**Havering**  
LONDON BOROUGH

6<sup>th</sup> July 2021

**London Borough of Havering (20025659) London Borough of Havering Response to Updated Draft Development Consent Order (REP9-058)**

Project Title:	M25 junction 28 improvement scheme	
Drawing Title:	LAND PLANS REGULATION 5(2)(i) Sheet 2 of 4	
Drawing Number:	TR010029/APP/2.2	1
HE PIN: HE551519	Scale: 1:2,500	Original Size: A1

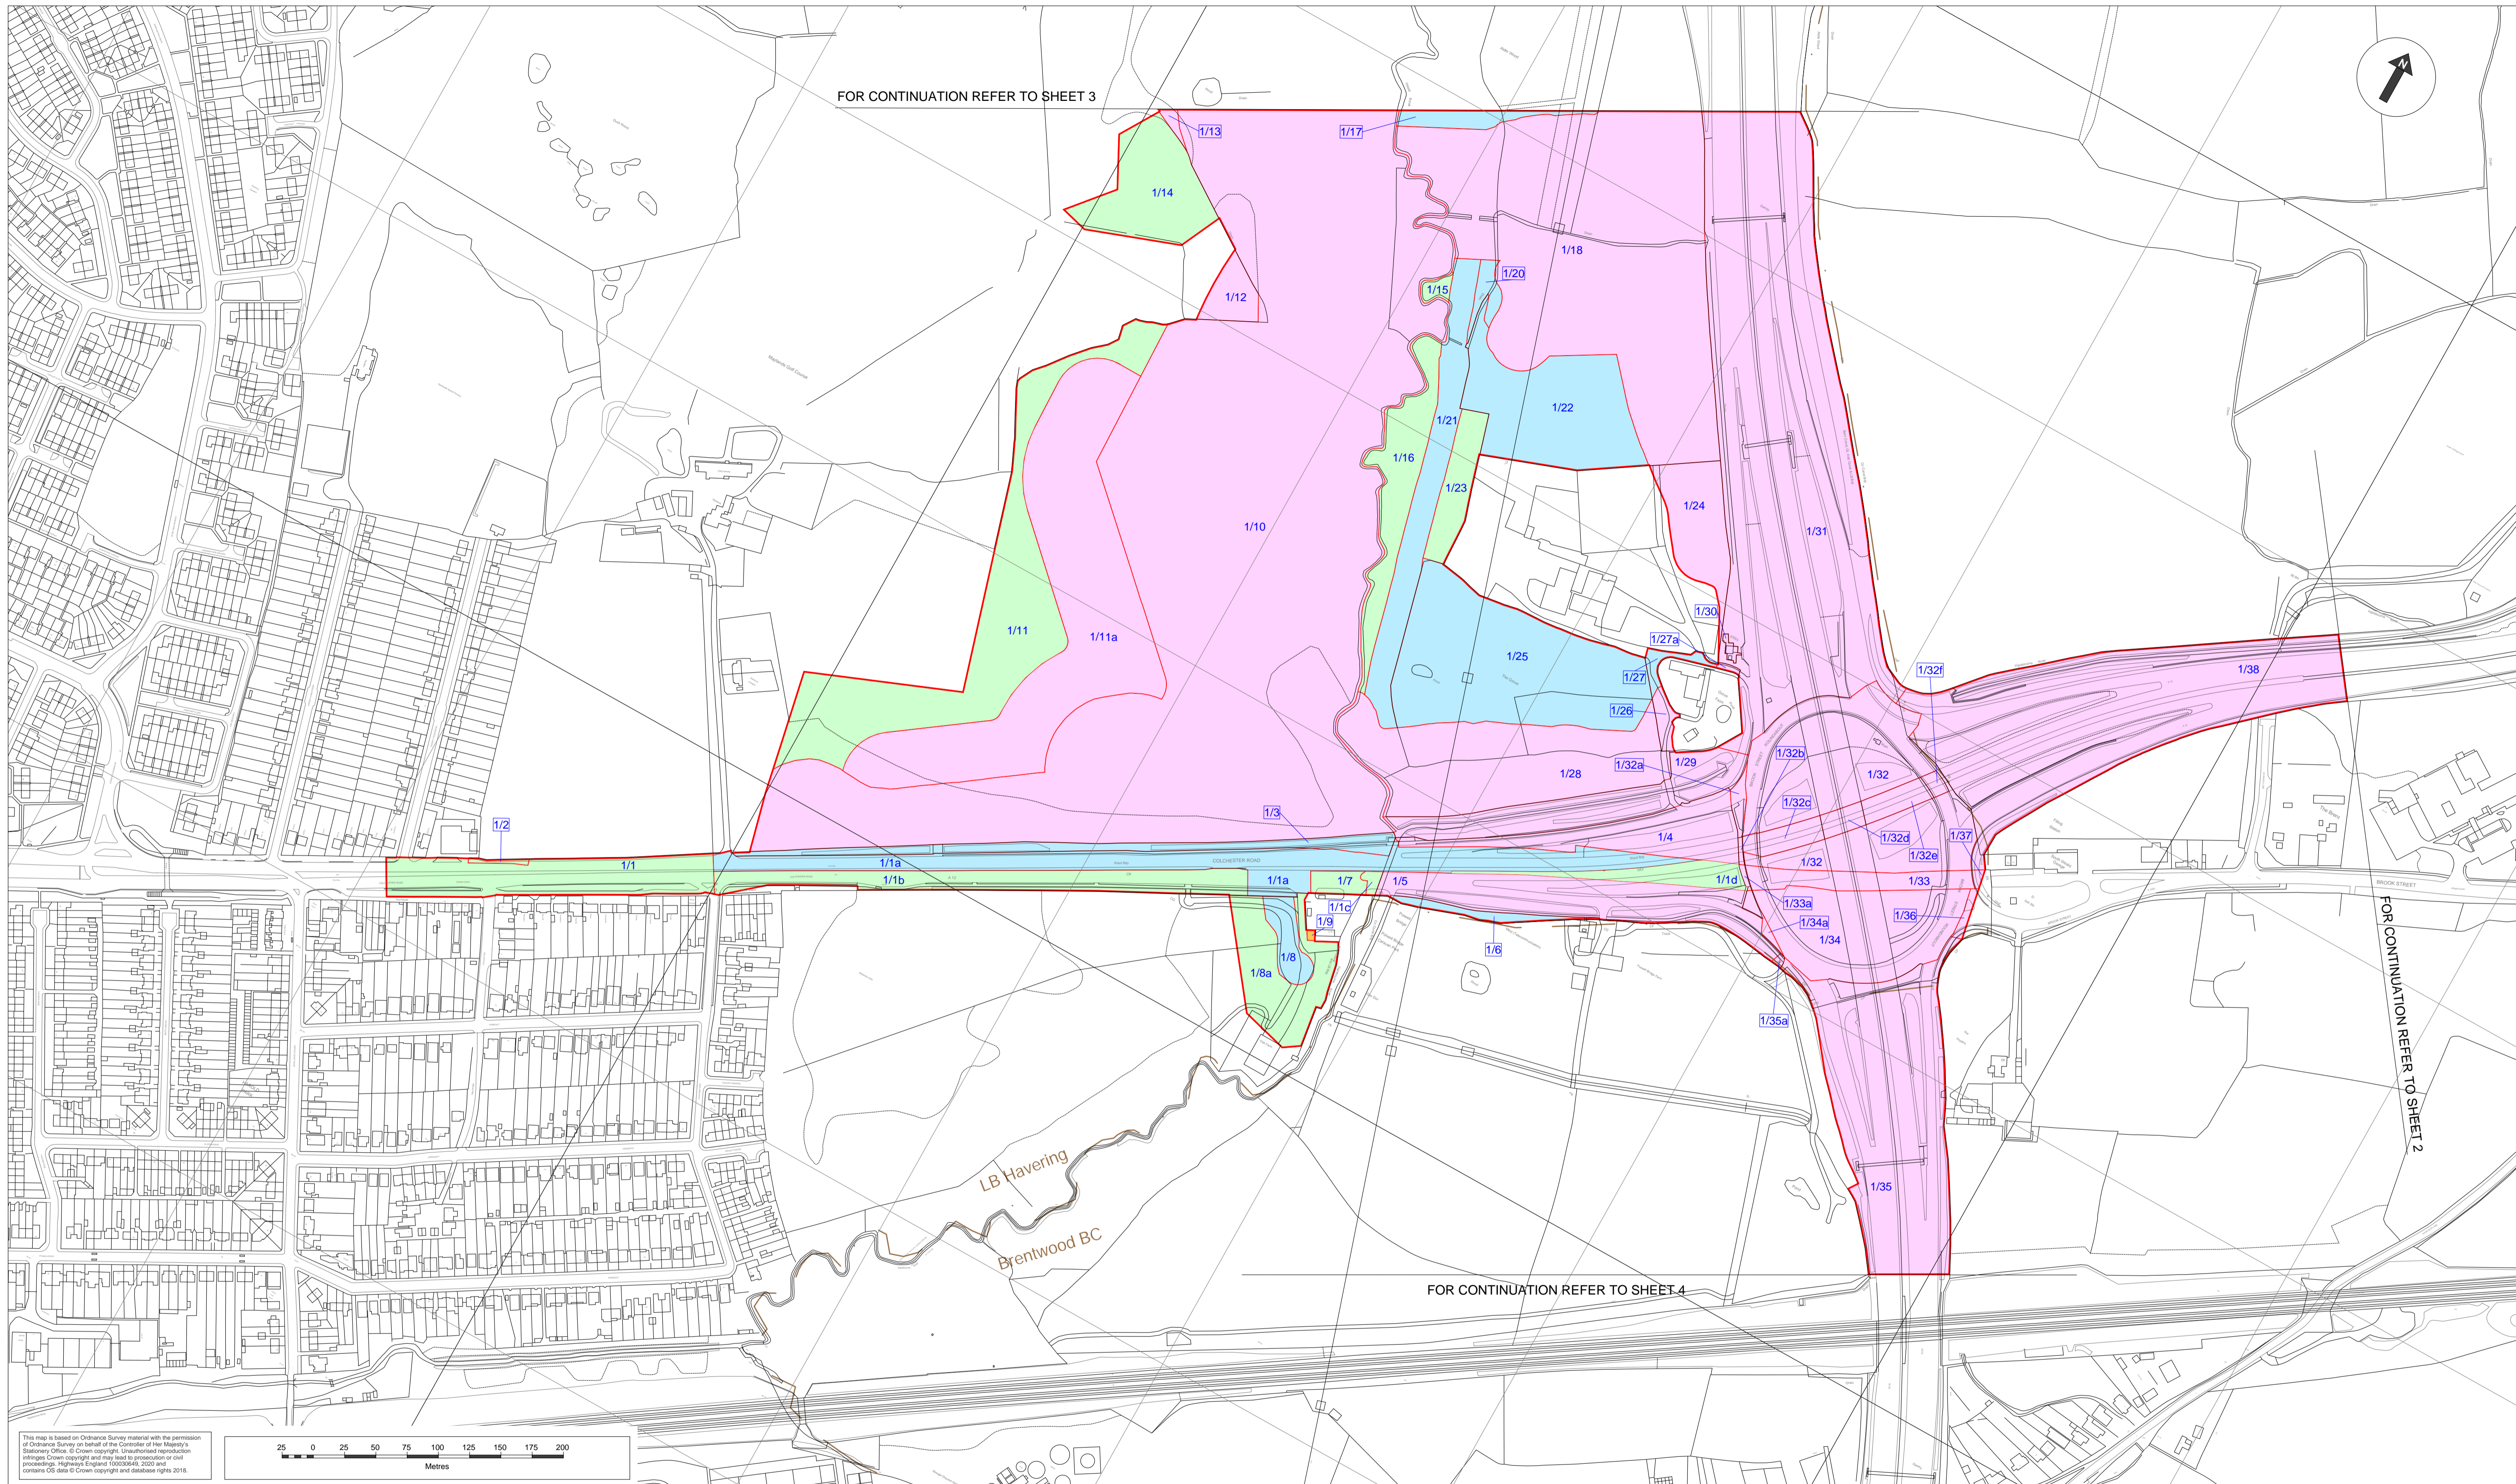
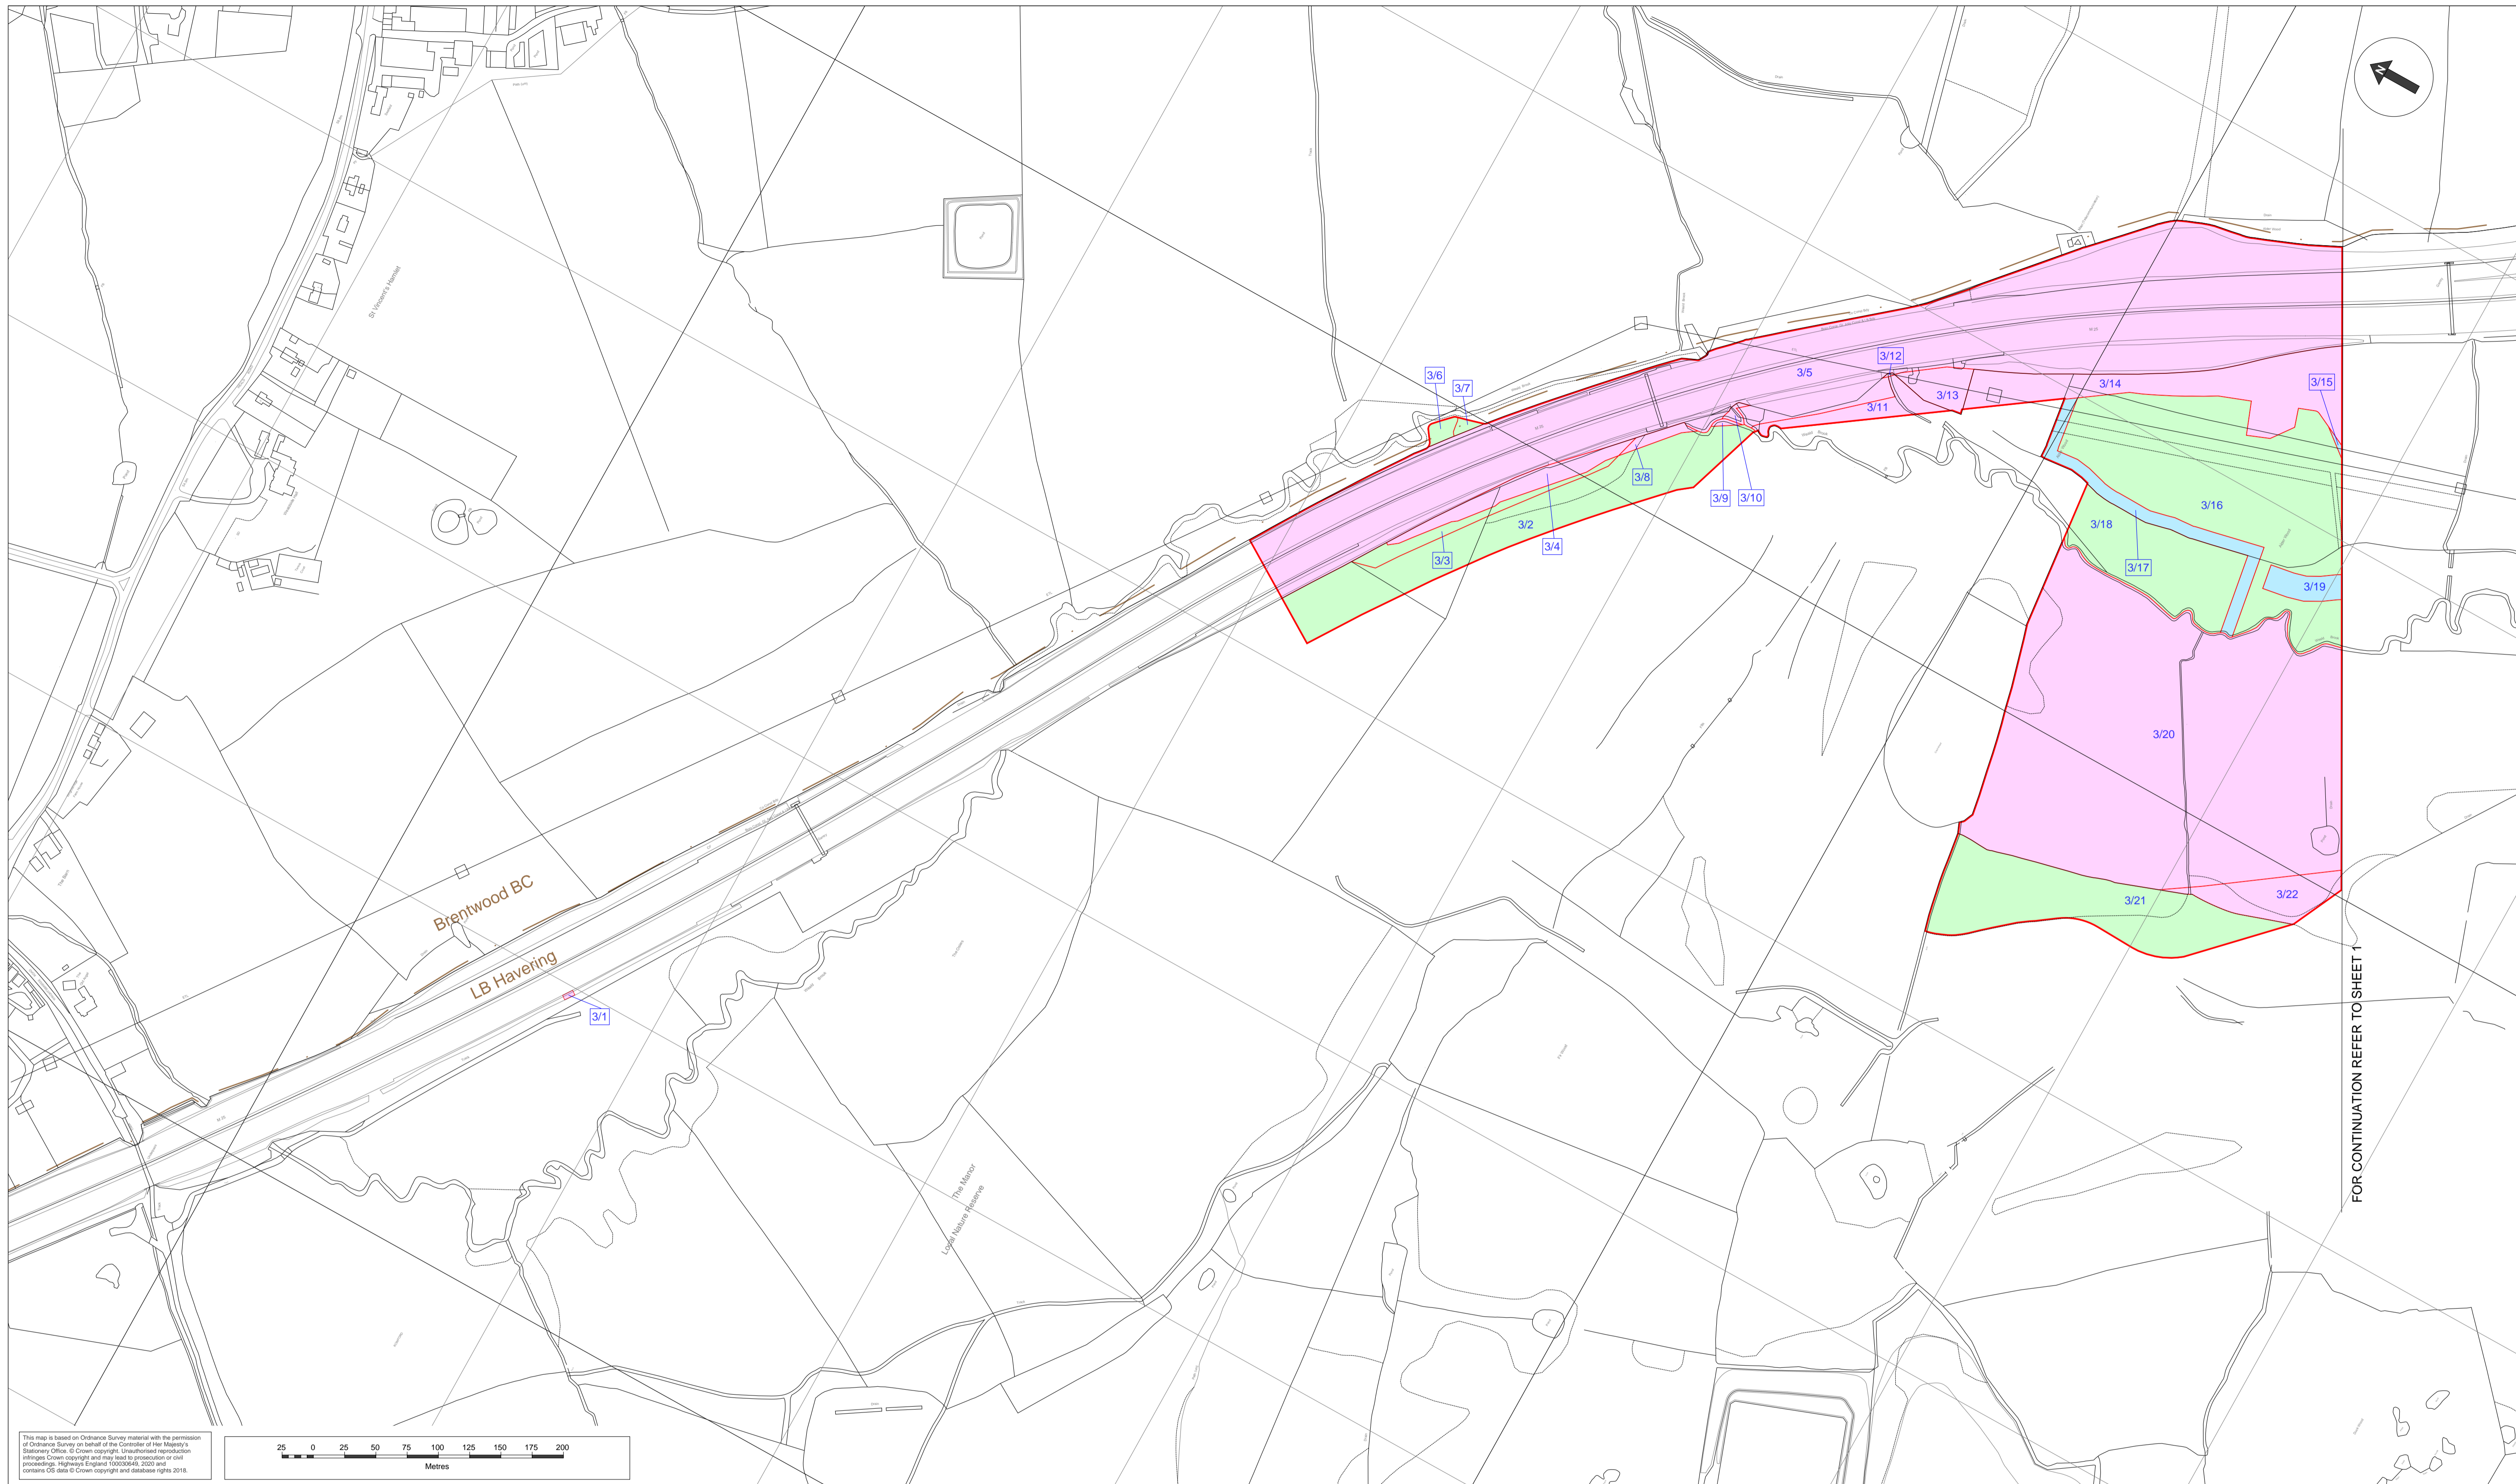
LB Havering notes that in Schedule 6 Article 28 1/25a that the installation, access, monitoring and maintenance of bird boxes is now included in the Schedule, and this is welcomed and supported. LB Havering notes that the provision of the fencing for the control of deer is not included in the land plans in Schedule 6. LB Havering requests that this is included in the relevant land plans.
